A1 in Northumberland: Morpeth to Ellingham

Scheme Number: TR010059

7.40 Applicant's Response to Secretary of State Consultation Responses

**Applicant's Response to Secretary of State Consultation
Responses**

Figure 1 - Ancient Woodland Strategy Plan

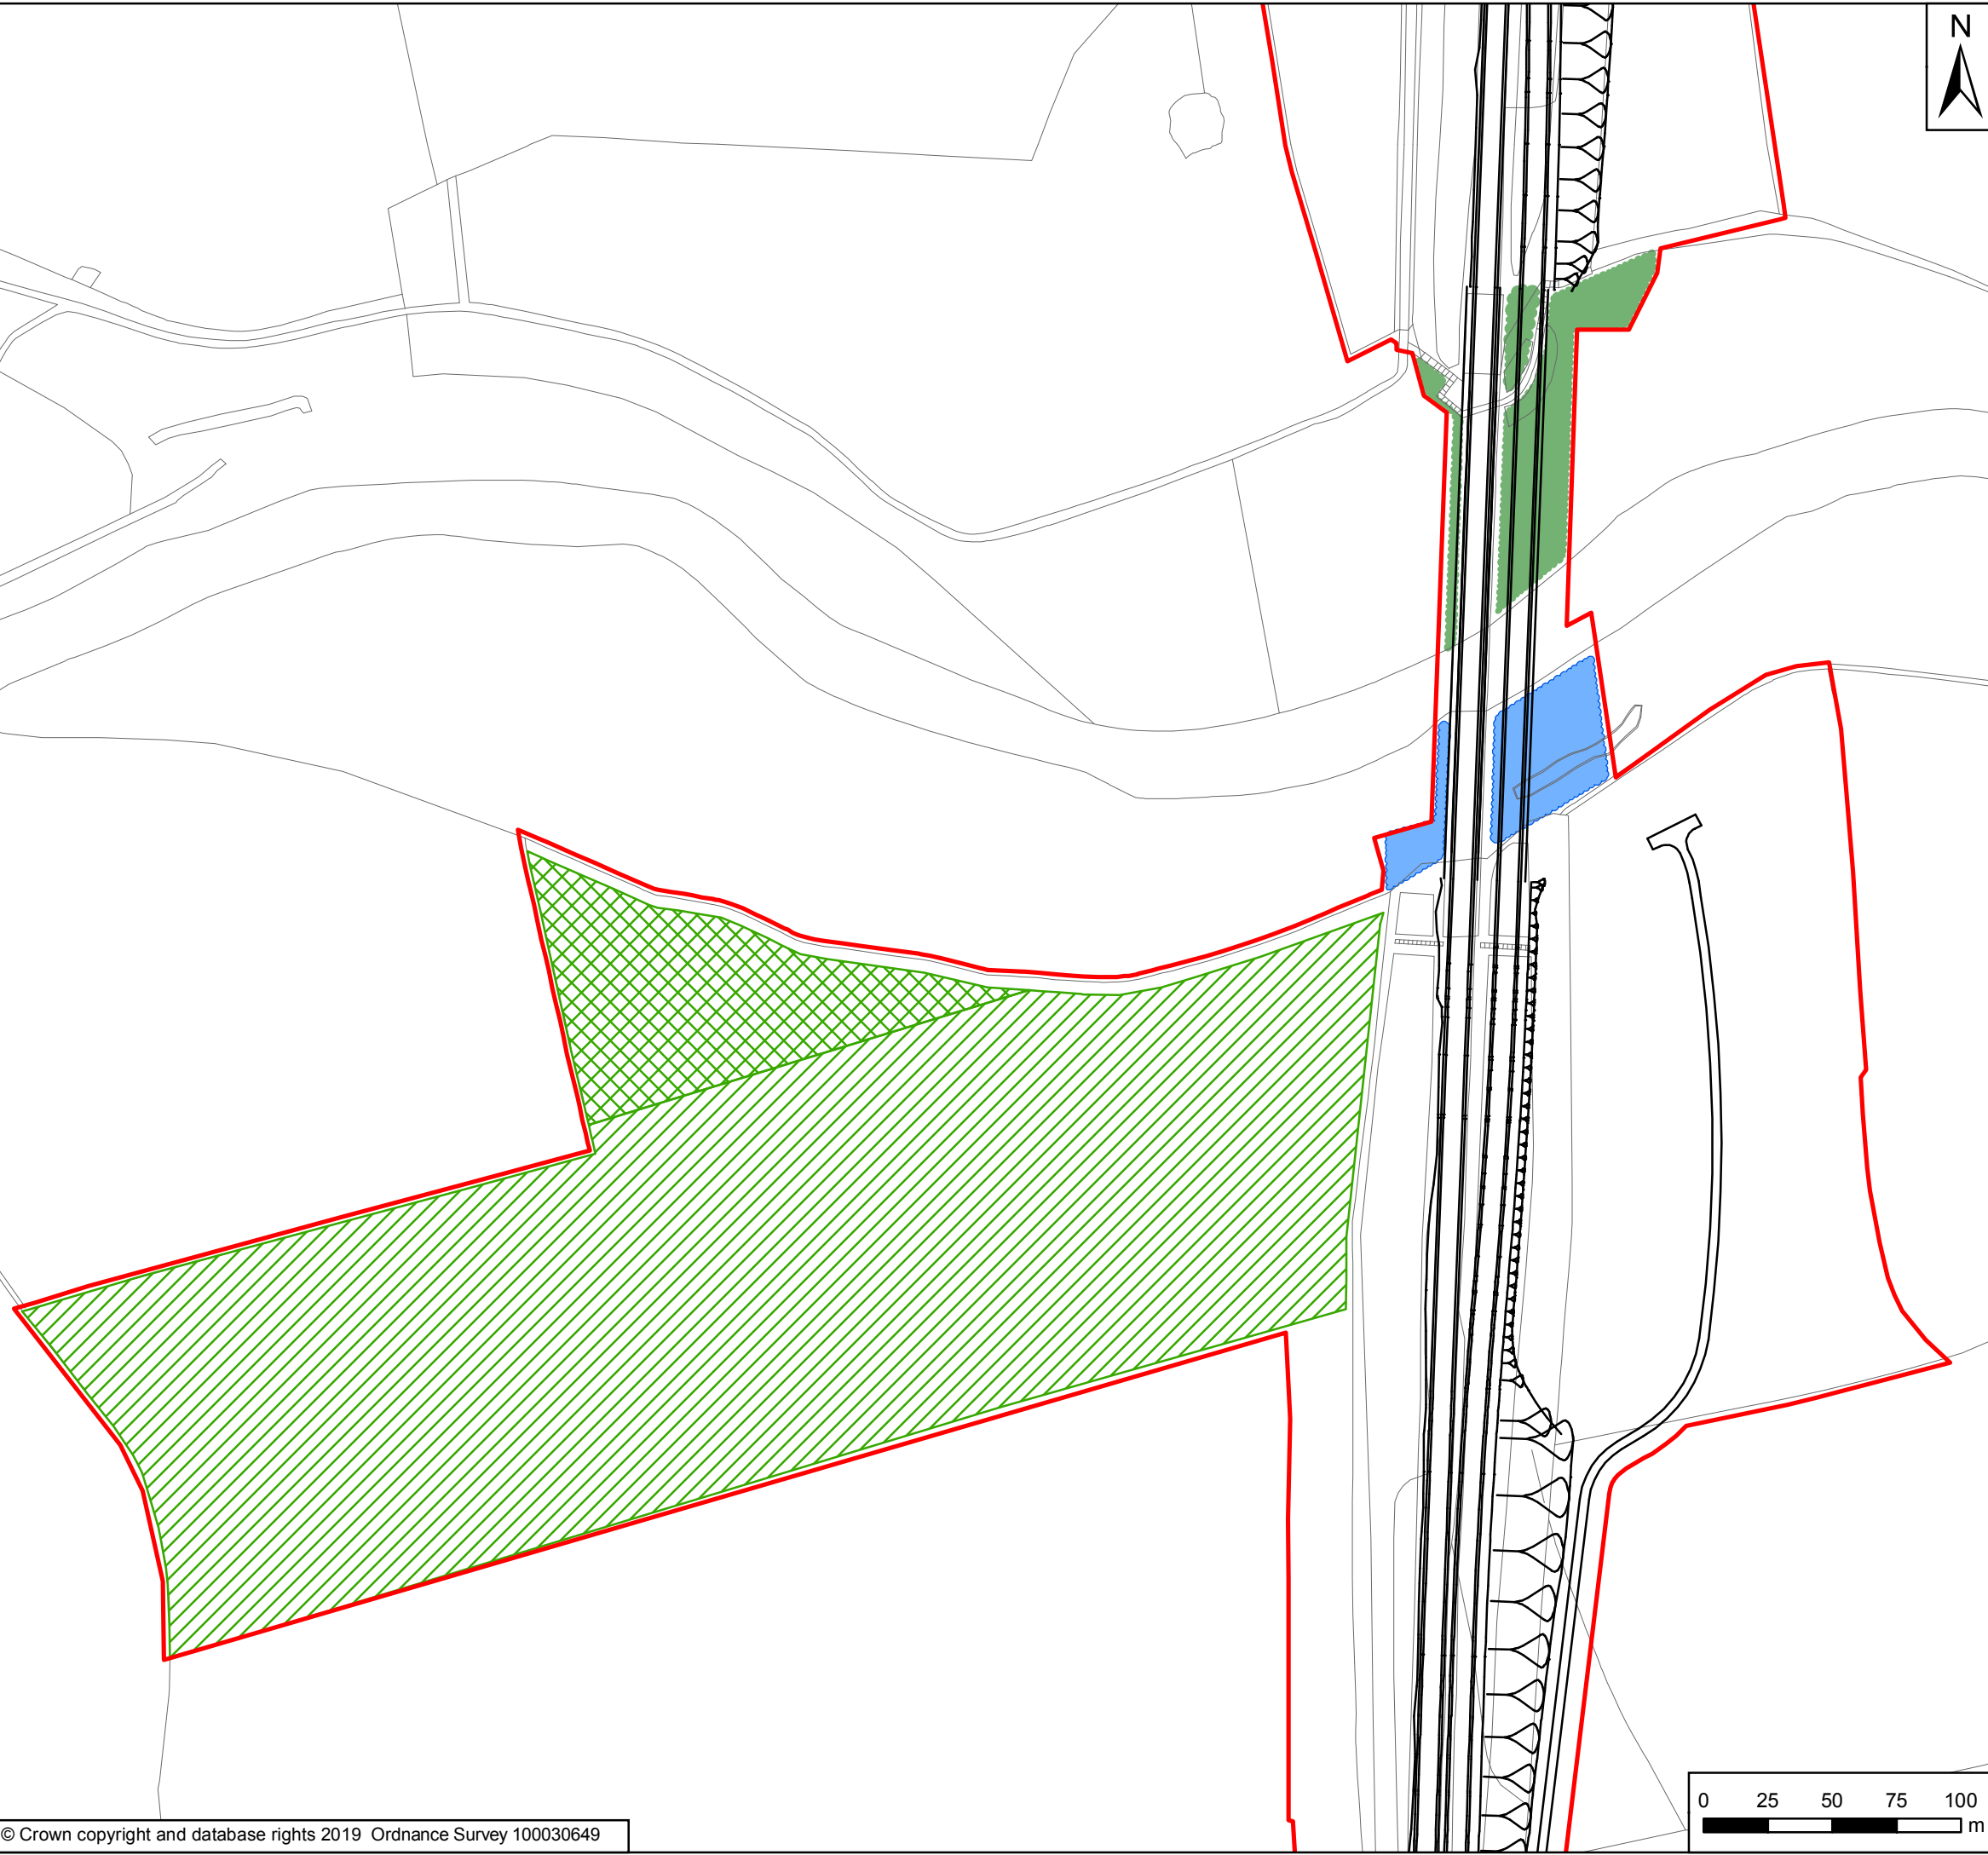
Ref. No.	Response:	Applicant's Response:
	woodland type; planted in a low density, non-modular, naturalised layout and are agreed by NCC's Ecology Team.	
6	NWT welcomes the proposed salvage techniques that will be undertaken, where possible, to take substrate and flora from the ancient woodland donor site to the receptor area of the Woodland Creation, mentioned within the CEMP.	<ol style="list-style-type: none"> 1. The Applicant notes NWT's support for the proposed salvage techniques.
7	For the Ancient Woodlands, an irreplaceable habitat, in general the conclusion is that the Scheme would result in a permanent/irreversible impact that may negatively impact the key characteristics of the resource and therefore the impact is classified as Major adverse . We would encourage the compensation scheme to reach further and include privately owned ancient woodlands, where landowners can be confirmed and agree to a management plan for enhancement. Inclusion of monitoring of this compensation, in a LEMP, is vital to assess the success and appropriateness, to allow for alterations to management and inform future schemes.	<ol style="list-style-type: none"> 1. The Applicant considers the proposed compensation detailed in paragraphs 7.1.11 to 7.1.15 of the Updated Biodiversity Air Quality Assessment submitted at the deadline on 21 March 2024 for predicted impacts to the five ancient woodland sites (as listed in b to f of paragraph 7.1.6) to be appropriate and proportionate. As detailed in paragraph 7.1.14, "<i>the five ancient woodland sites have been considered as a resource, rather than considering each parcel separately</i>" and compensation devised accordingly. 2. The proposed compensation (habitat improvements) has been identified and agreed in consultation with Northumberland County Council (NCC), who would take on the responsibility for the proposed habitat improvements (to be funded by the Applicant). The management of this compensation would therefore be undertaken by NCC. The compensation is secured by measure ExA: S-B100 of the Outline CEMP and a legal agreement between NCC and the Applicant. As this agreement is still to be concluded, the Applicant considers that an additional requirement should be included in the draft DCO in order to secure the obligation for the agreement. The Applicant has proposed that an additional paragraph (5) should be added to requirement 15. The wording of this proposed addition is presented within the Applicant's response to the SoS as submitted alongside this response.

Ref. No.	Response:	Applicant's Response:
9	<p>NWT would always request that all species used in the landscaping (for all habitats) be appropriate locally native species, not just UK native, and that hedgerows are species rich with 8 or more species. The ancient woodland species mix proposed on the landscaping plan (available through the link) includes horse chestnut, which is not native and beech which is not locally native and introduced to Northumberland. We would request that these two species be removed, if not already and a more appropriate species be used. In the indicative woodland block planting mix, beech and large-leaved lime are listed. Again, these species are not locally native and we would request that these species be removed from the list. While beech is a UK native, it will out compete and shade out locally native species, while the heavy and persistent leaf litter will smother ground flora and greatly reduce natural regeneration and biodiversity. Considering the amount of work that has gone into the proposals, this is a minor alteration and by including more appropriate species there should be positive impacts rather than negative impacts.</p>	<ol style="list-style-type: none"> In relation to “locally native”, please see the response to Ref 4 above. The Applicant confirms that reinstated and created hedgerows will be native and species-rich (as detailed in measures S-L2 and B-L1 of the Outline CEMP, as submitted at the deadline on 21 March 2024 and updated and submitted alongside this response, and within the Biodiversity No Net Loss Assessment for the Scheme [REP5-038]). However, the Applicant has not made a specific commitment to creating hedgerows with 8 or more species and does not consider this to be necessary. It is assumed that NWT is referring to the ancient woodland planting mix detailed within Appendix A of the Ancient Woodland Strategy [REP9-012] (no link available within the response). The Applicant confirms that both horse chestnut and beech were removed from the Ancient Woodland Strategy during the Examination in response to similar comments from Natural England (see [REP9-012]).
